Our Ref: Y/40/15/PL
Your Ref:

Town & Country Planning Act 1990 (as amended)
Town and Country Planning (Development Management Procedure) (England) Order 2015
Application for Planning Permission

Development Installation of 4 no. 1.2 x 1.2 UPVC white double glazed windows. Change of use from B1 (Business) & B8 (Storage & Distribution) to sheltered employment.

Location 23/24 Orchard Business Park North End Road Yapton

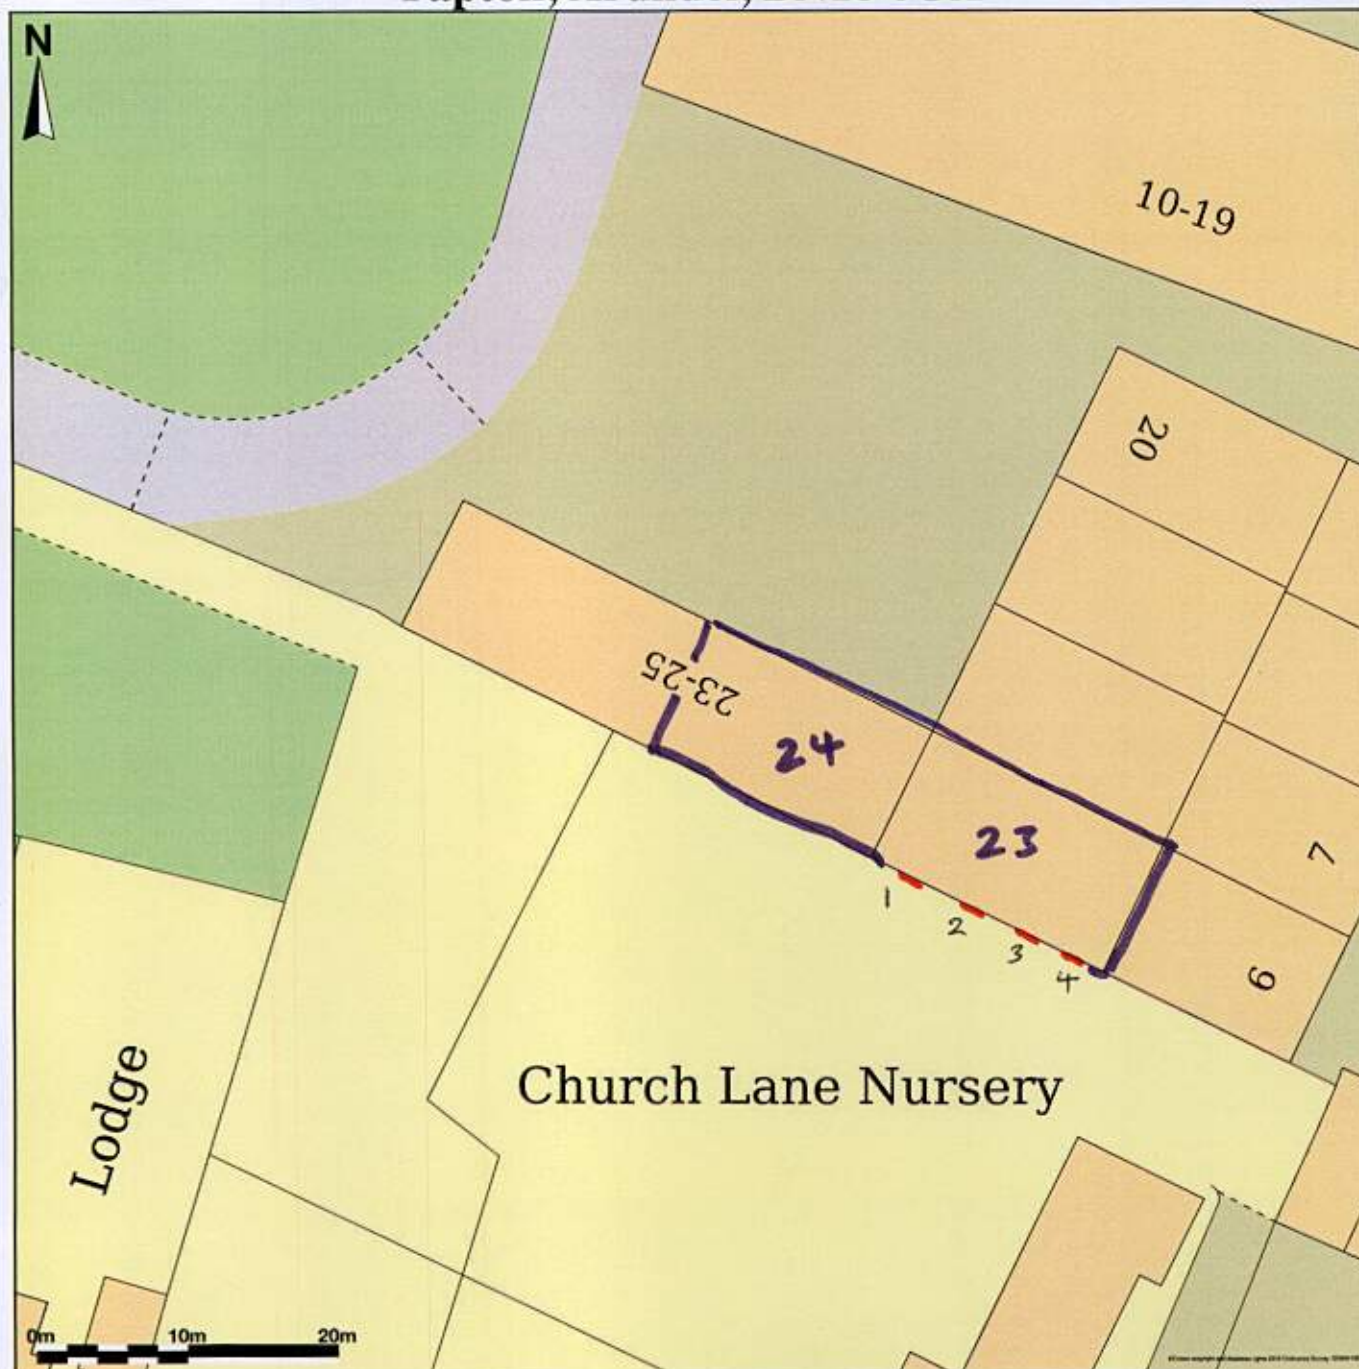
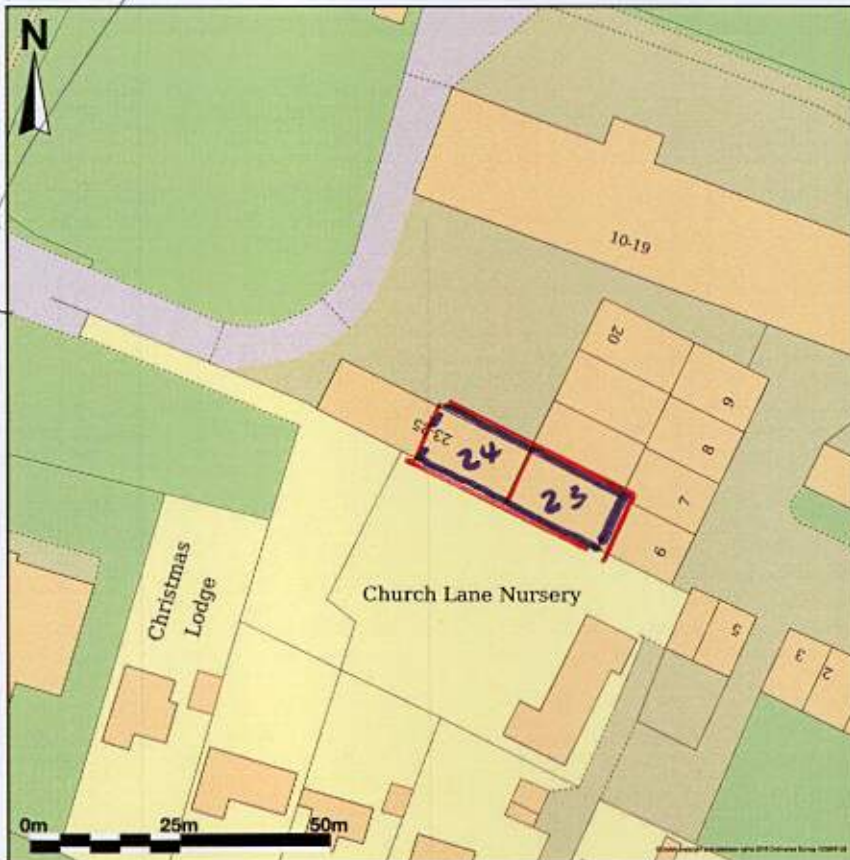
Location Plan

Please submit 1 electronic or 3 paper copies of an amended location plan at a scale of 1:1250 or 1:2500 for rural areas showing 2 named roads clearly edged in red and any other land edged in blue

PROPOSED INSTALLATION OF
4 NO 1.200 X 1.200 WHITE UPVC D/GLAZED
SINGLE OPENING WINDOWS SOUTH
SIDE

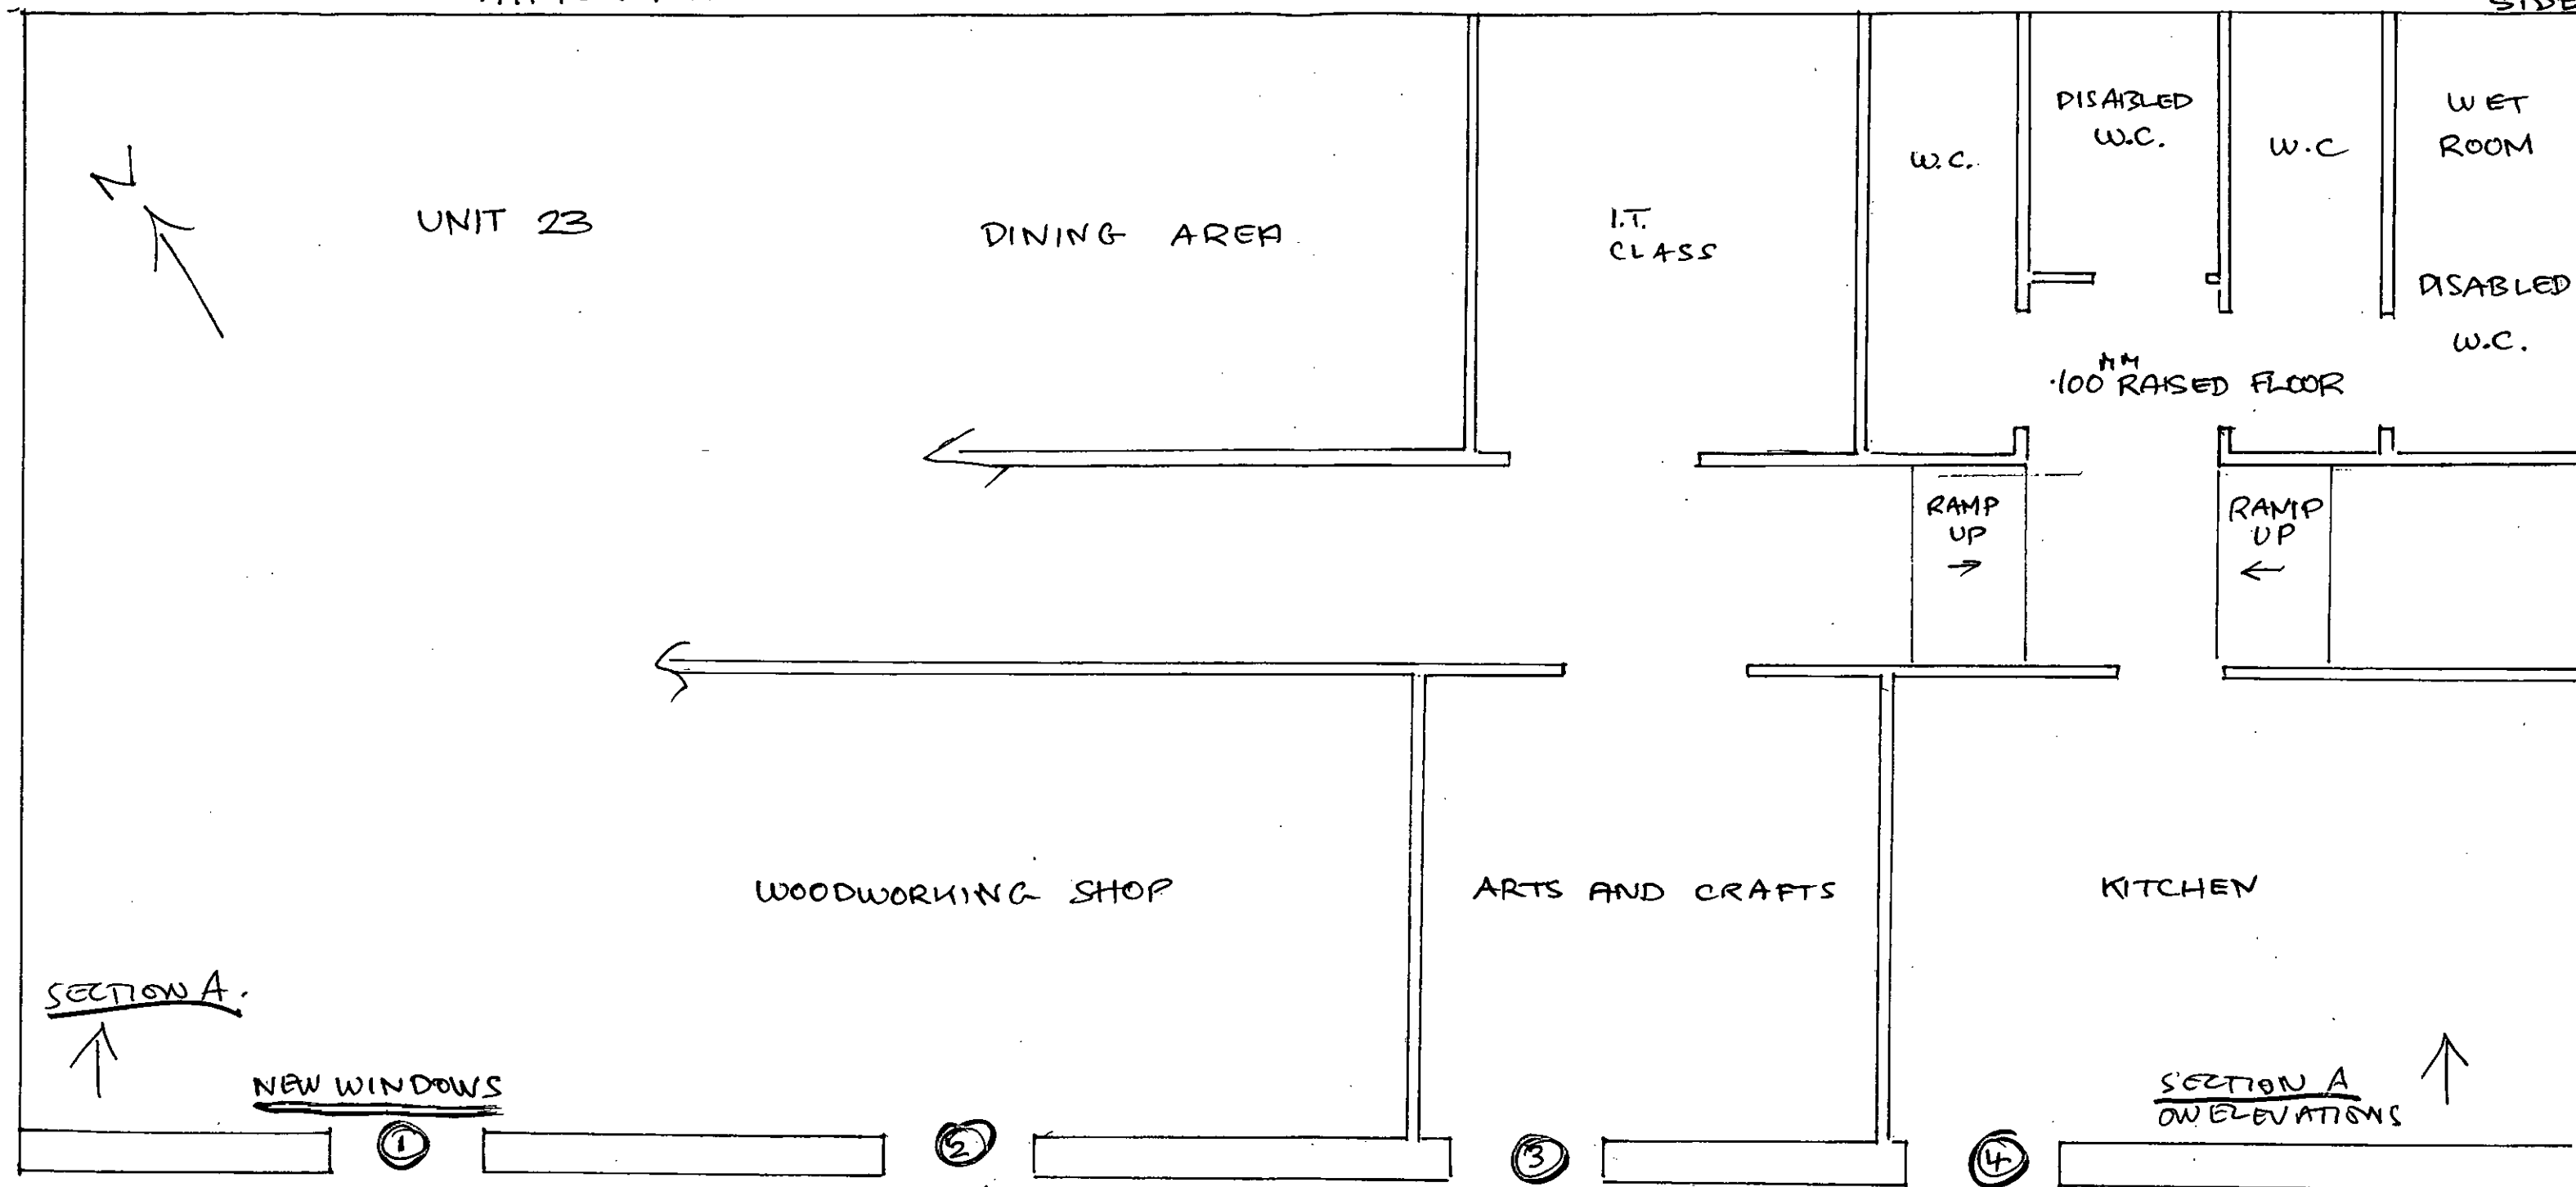
Please forward elevations/details/pictures/manufacturers information of the windows including dimensions. We require existing and proposed. The drawings sent are not acceptable.
